**Response to Endeavour Energy feedback to State Significant Development SSD-10391 application for the New Liverpool Public School**

**Sydney September 2, 2021**  
Ref. No. 207148

DRAWING
SITE PLAN
PRINT DATE 6/05/2021
ISSUE B

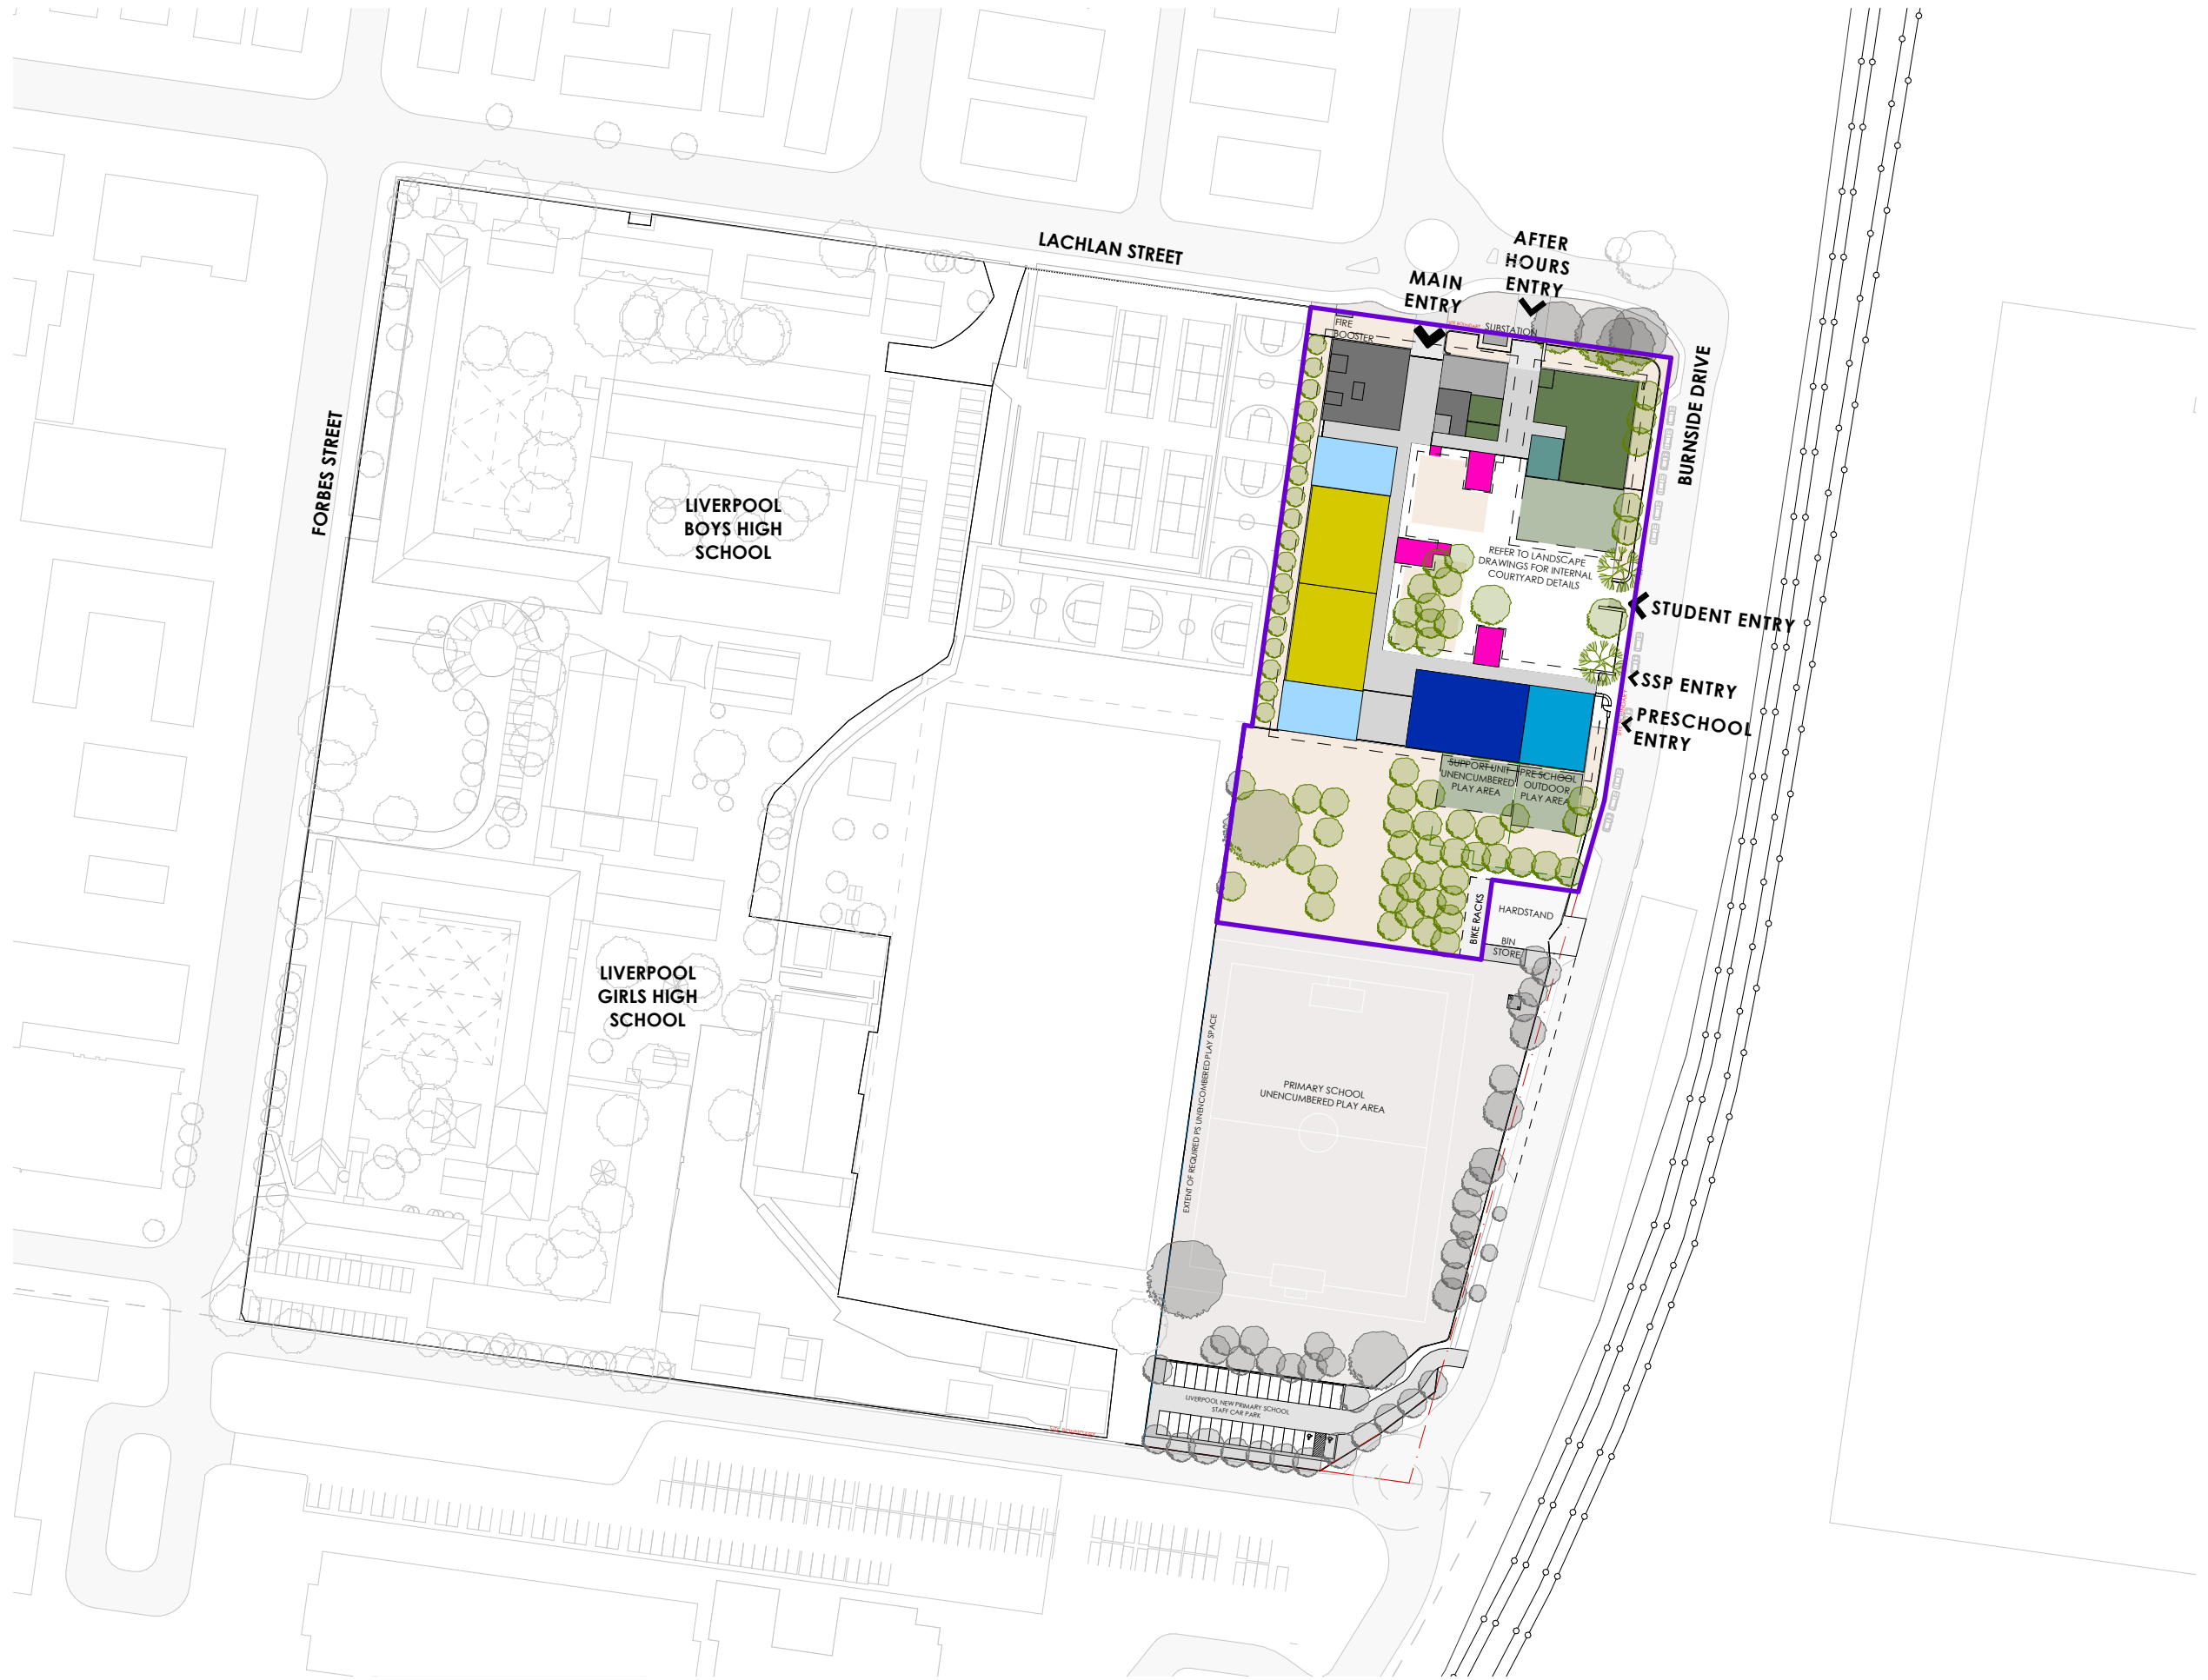
1. We note Endeavour Energy sees the provision of a padmount substation as a positive and we appreciate this feedback.
2. An easement of 2.75 x 5.5 metres as noted for a single transformer has been provisioned in the architectural design. The easement has been located on the the property boundary in order to facilitate access from the street side.

3. No building is to be built within 3m of the substation housing as confirmed by the architects drawings.
4. There are no swimming pools within 5m of the proposed easment location.

5. Personnel access doors and fire exit doors to a building are not located within the fire restricted area as confirmed by the architects drawings.
6. No other services will run through the proposed padmount substation easement

7. 10m clearance is maintained between the substation and any fire hydrants and booster valves as confirmed by the architects drawings.
8. Landscaping is proposed to be provided around the kiosk substation which is yet to be designed. Any landscaping that is proposed will be designed and selected in accordance with Endeavour Energy requirements.
